**WELWYN HATFIELD BOROUGH COUNCIL  
ASSISTANT DIRECTOR (PLANNING)**

**DELEGATED APPLICATION**

**Application No:** 6/2024/0122/PN27  
**Location:** Woodlands Well Road Northaw Potters Bar EN6 4BN  
**Proposal:** The enlargement of a dwellinghouse by the construction of two additional storeys  
**Officer:** Ms Syndsey Ballet

**Recommendation:** Prior Approval Required and Refused

Project Address	Woodlands, The Ridgeway, Hertfordshire EN6 4 BN
Project Description	Proposed Extensions
Drawing Title	Prior Notification Main House_Proposed Main House Floor Plans Sheet 2
Drawing No.	2755-1309
Rev.	A

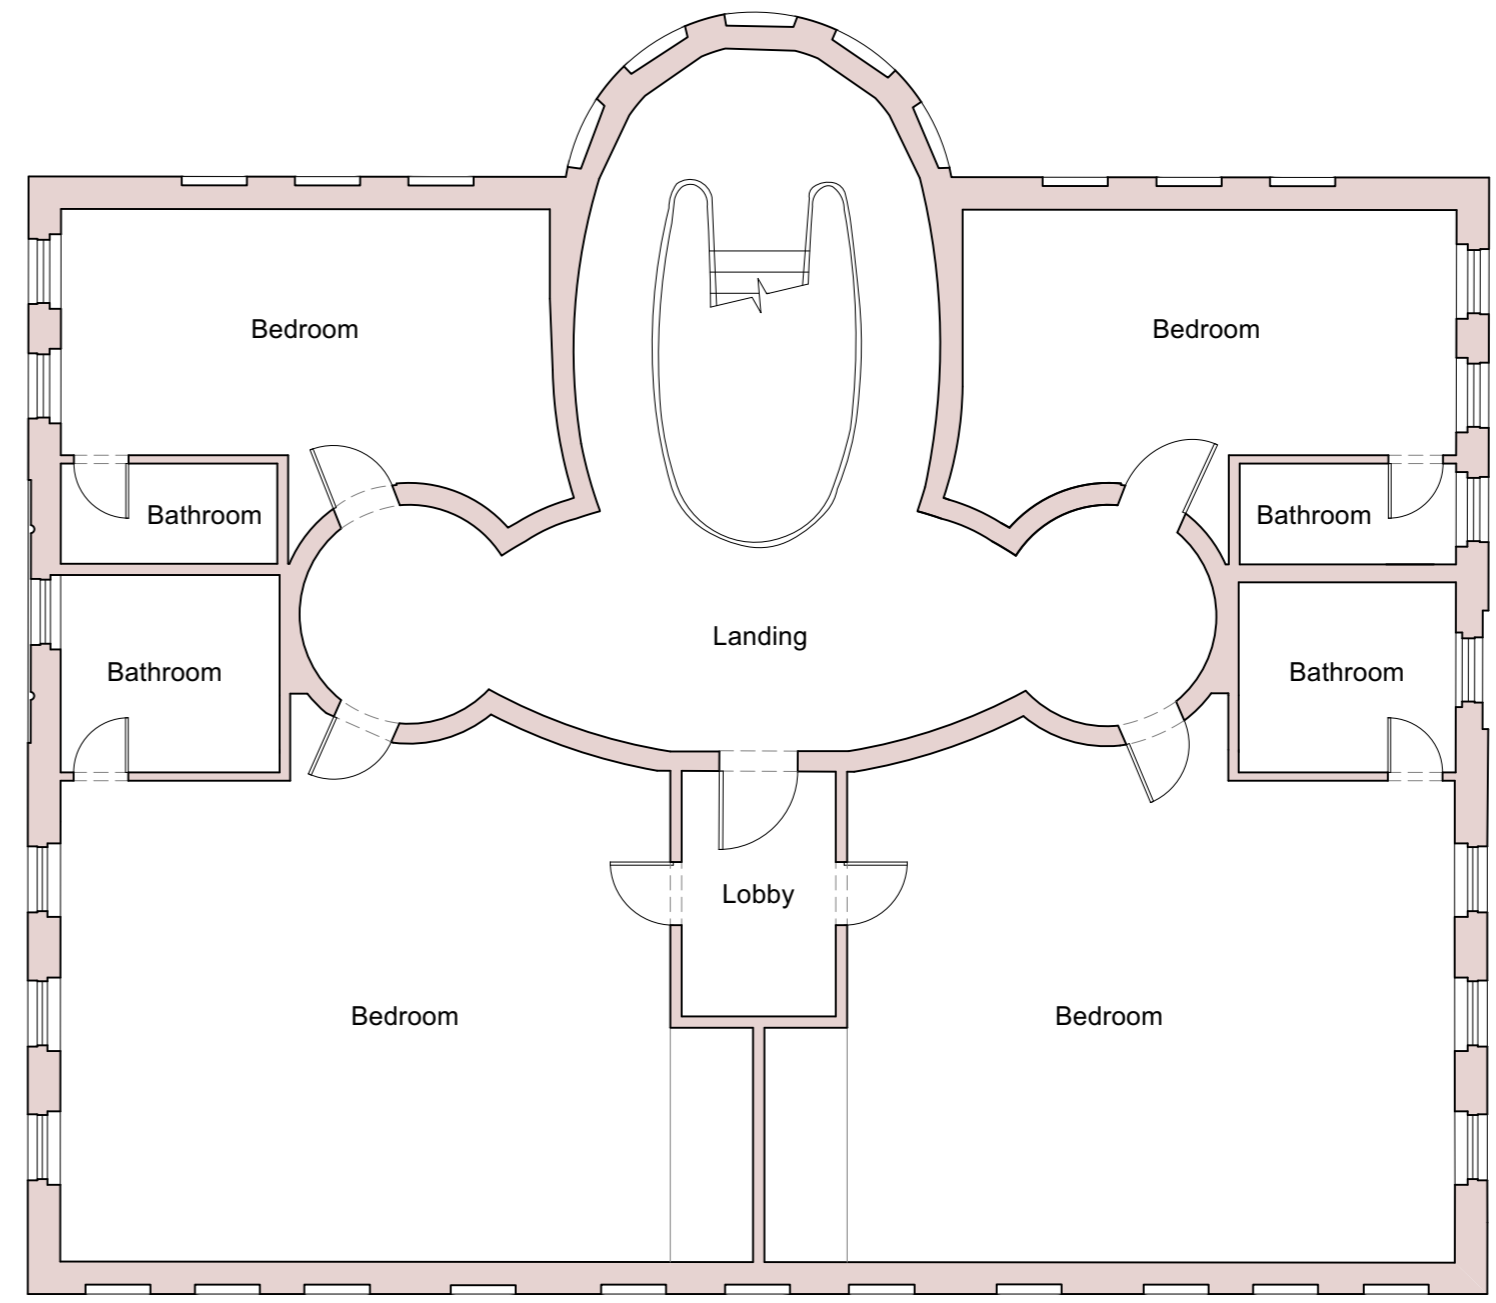
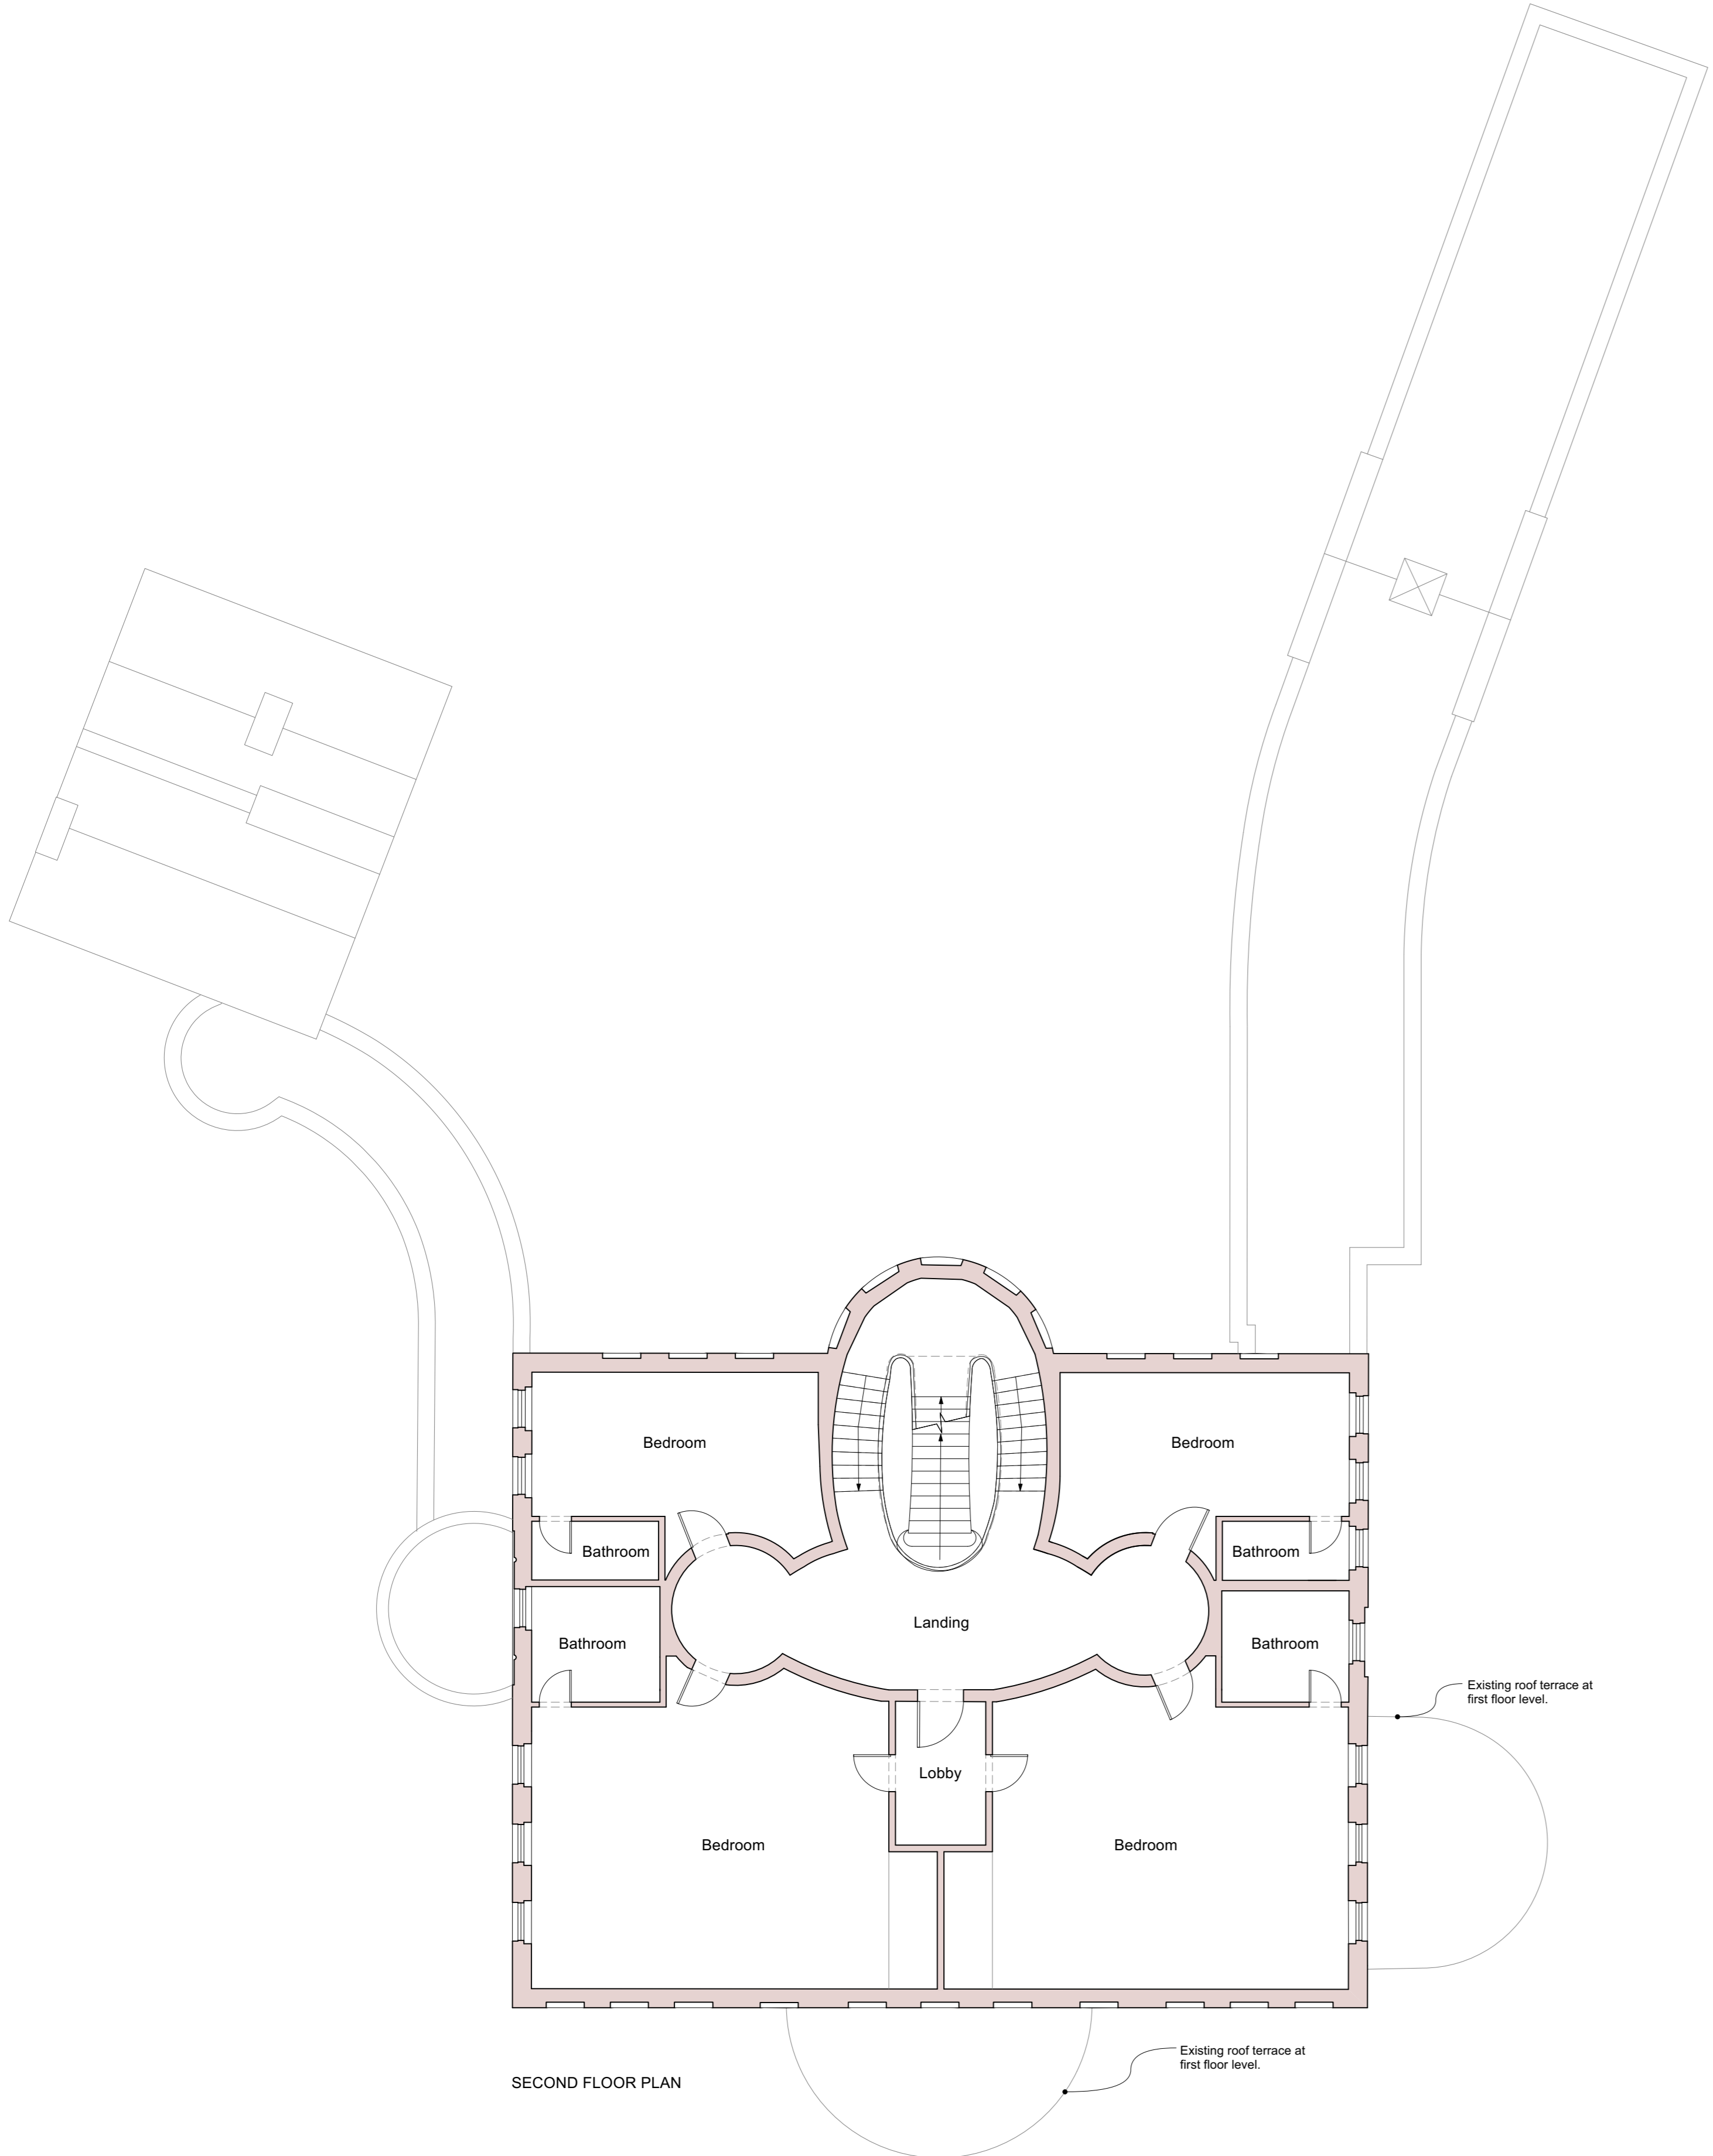
The proposal seeks prior approval for the construction of two additional storeys to facilitate the enlargement of the dwelling to a maximum of approximately 17.8m in height. Although substantial in height, the position of the dwelling set well back from the highway would significantly limit potential views of the proposed upward extension. Some views could be possible from the surrounding landscape, however, these would be likely to be heavily filtered by vegetation, and the visual impact of the development would be moderated by the largely mid to long distances at which the development would be seen. Nevertheless, the extended dwelling would be clearly visible, prominent and imposing within its landscape setting as witnessed by anyone visiting the site.

The two storey extension would overwhelm the host dwelling in terms of its height, mass and scale. It would also fail to respect the surrounding context whereby buildings are generally single or two storeys in height.

Whilst the inclusion of 'blind windows' is acknowledged, the resultant dwelling would nevertheless lack the symmetry and proportions which are synonymous of regency architecture. The large expanses of windowless facades would appear contrived and would lend the building a top-heavy and disjointed appearance. As a result, the proposal fails to create a coherent and attractive form and instead represents a clear departure from the architectural style and appearance of the existing dwelling.

Accordingly, the development proposals are not of a high quality architectural design. Furthermore, the alterations to buildings fail to relate well to the character and proportions of the

existing building and the surrounding context in terms of height, mass, scale, detailed and design.
